From: Laura Gibbons <Laura.Gibbons@arun.gov.uk>
Sent: 05 October 2021 15:31
To: Planning.Responses <Planning.Responses@arun.gov.uk>
Subject: RE: Planning Consultation on: WA/88/21/DOC

Engineers Comments Regarding Condition 12

Application No: WA/88/21/DOC

Site Address: Global Technologies Racing Ltd Arundel Road Fontwell BN18 0SB

**Notes**  
This drawing is to be read in conjunction with all relevant Engineers and Architects drawings and the specification.

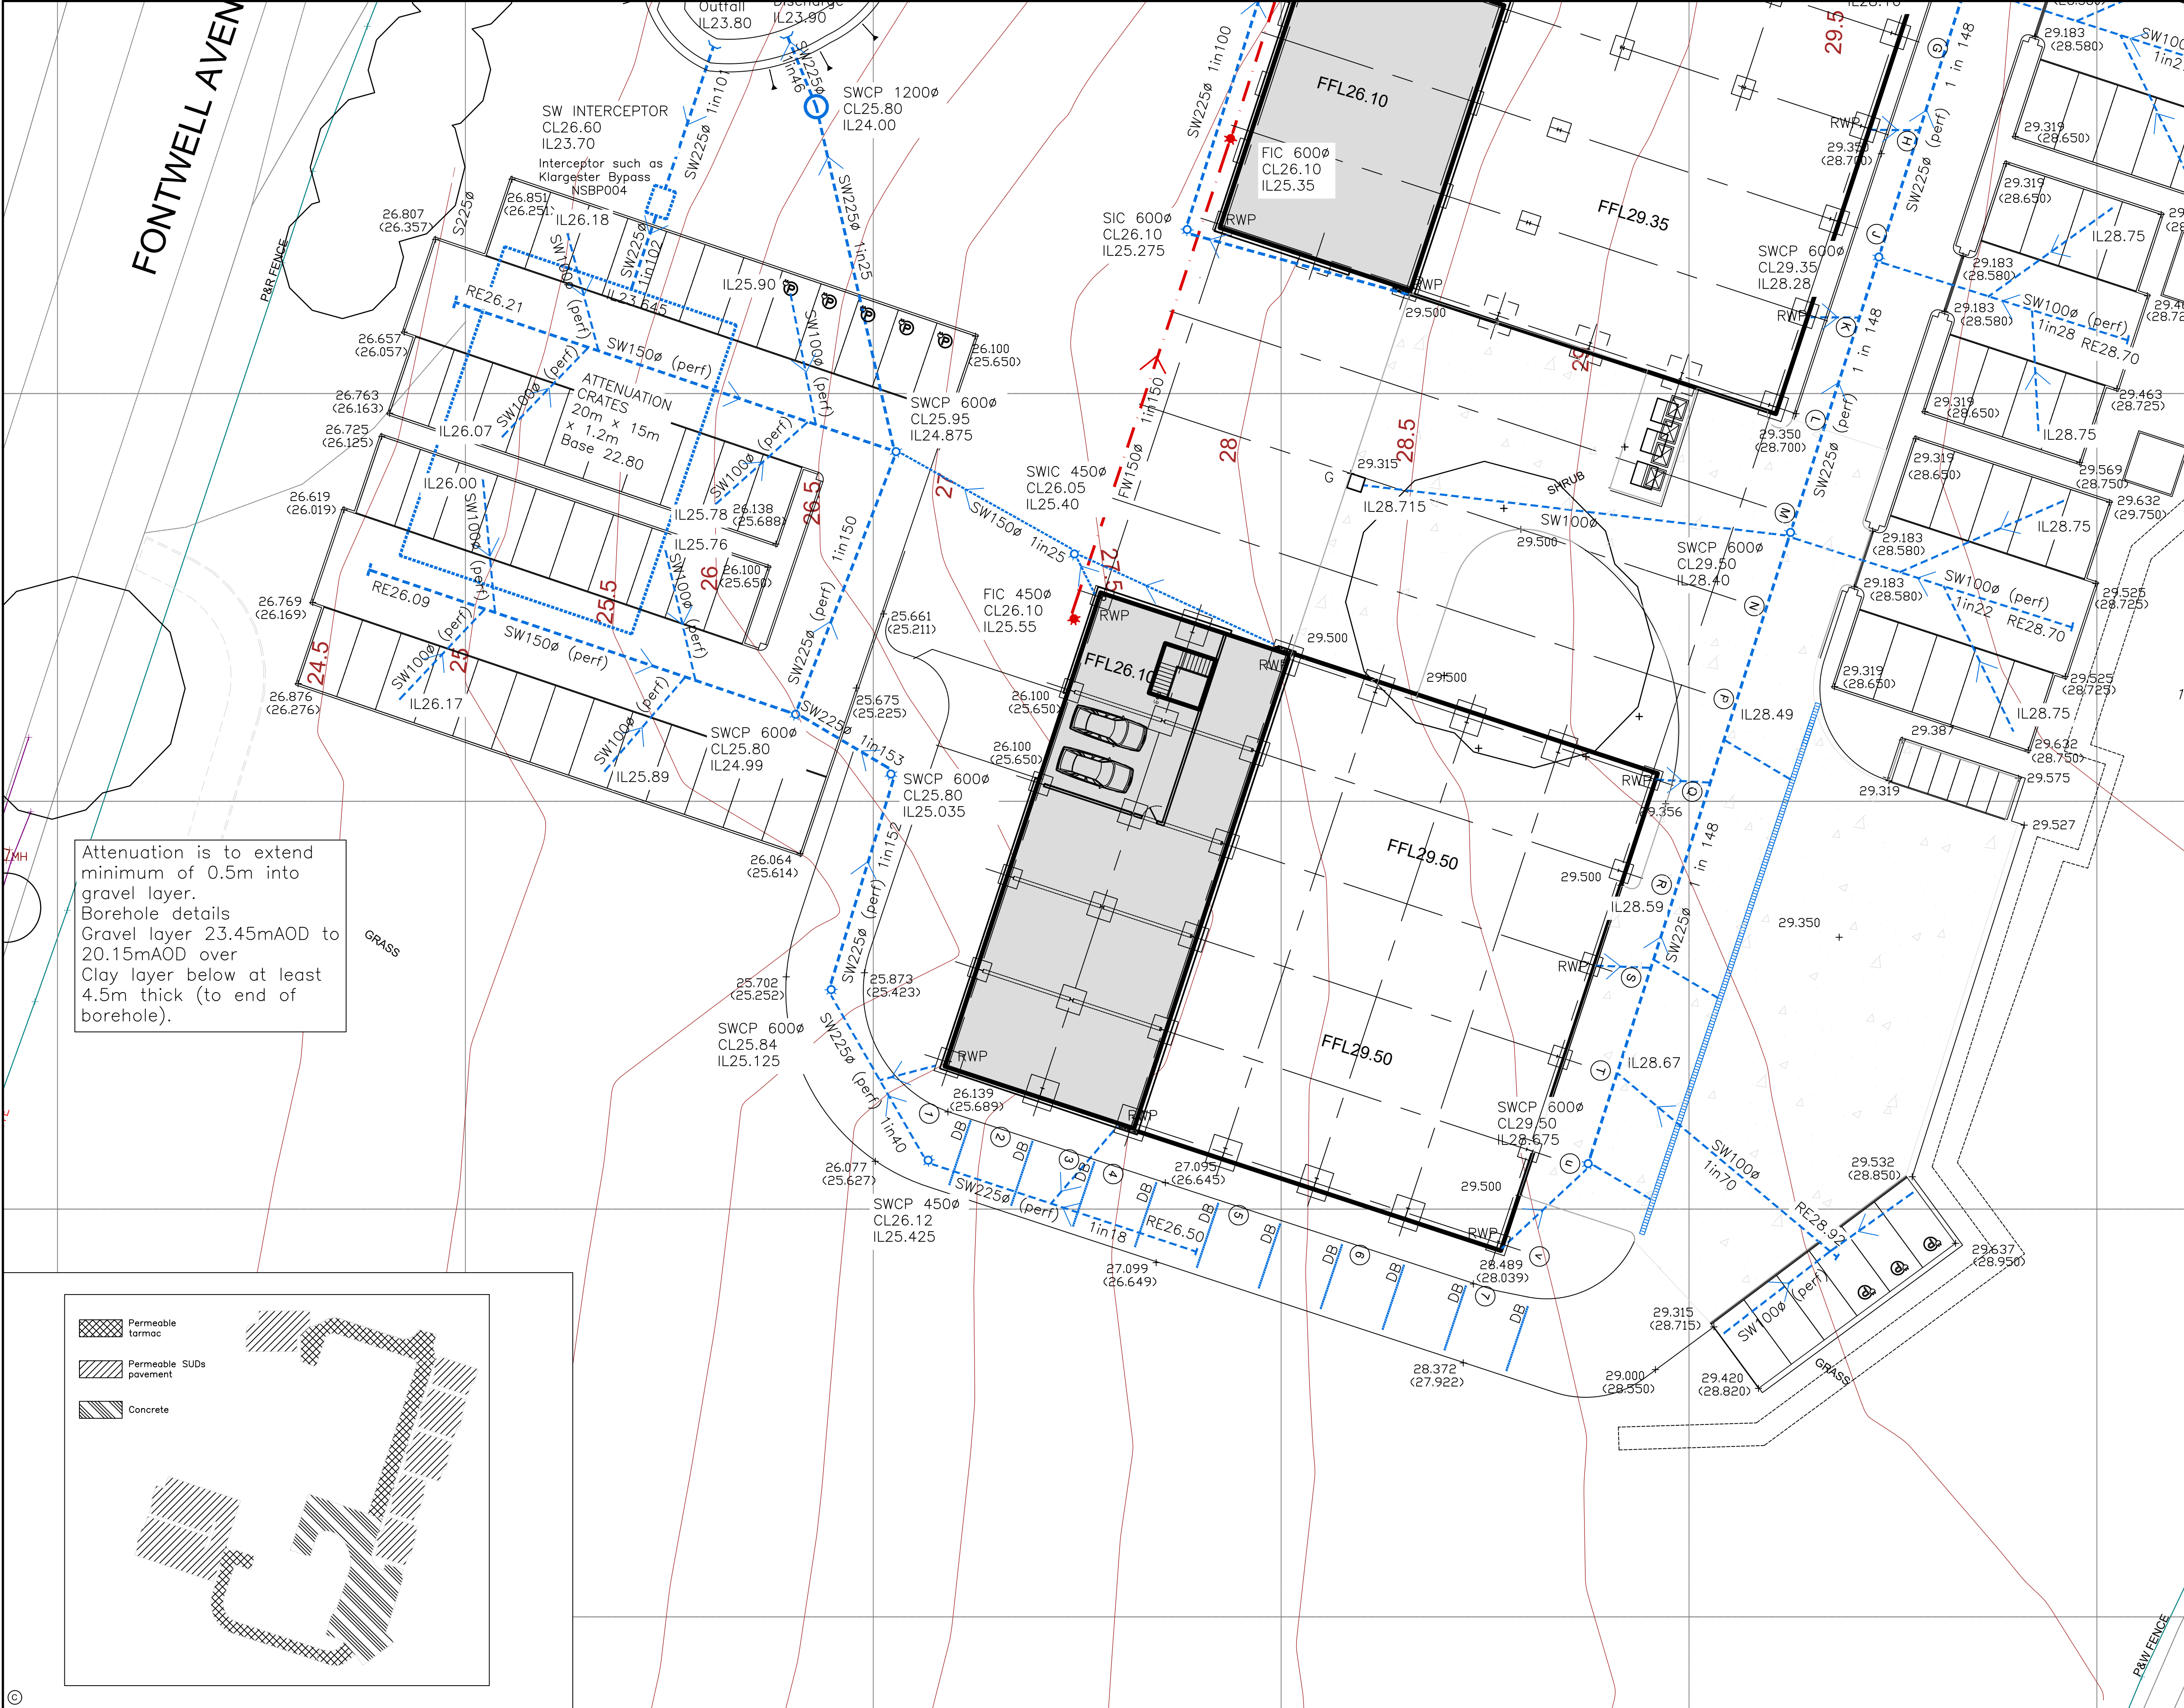
1. Finish and formation levels of permeable paving must be shown on layouts.
2. All pipes must be labelled with diameter and fall.
3. Invert levels of perforated pipes must be detailed.
4. Catchpits must be provided upstream of all connections into permeable paving and basins.
5. A dissolution assessment must be provided.
6. Calculations must use latest FEH rainfall data or a cv of 1.
7. Calculations should include printouts from the other models which form the cascade, i.e. the permeable paving features.
8. An impermeable areas/ catchment drawing must be provided.
9. Construction detail drawings should be provided of; pipe bed and surround, manholes, catchpits, basins, permeable paving, permeable paving perforated pipes, attenuation tanks, etc.
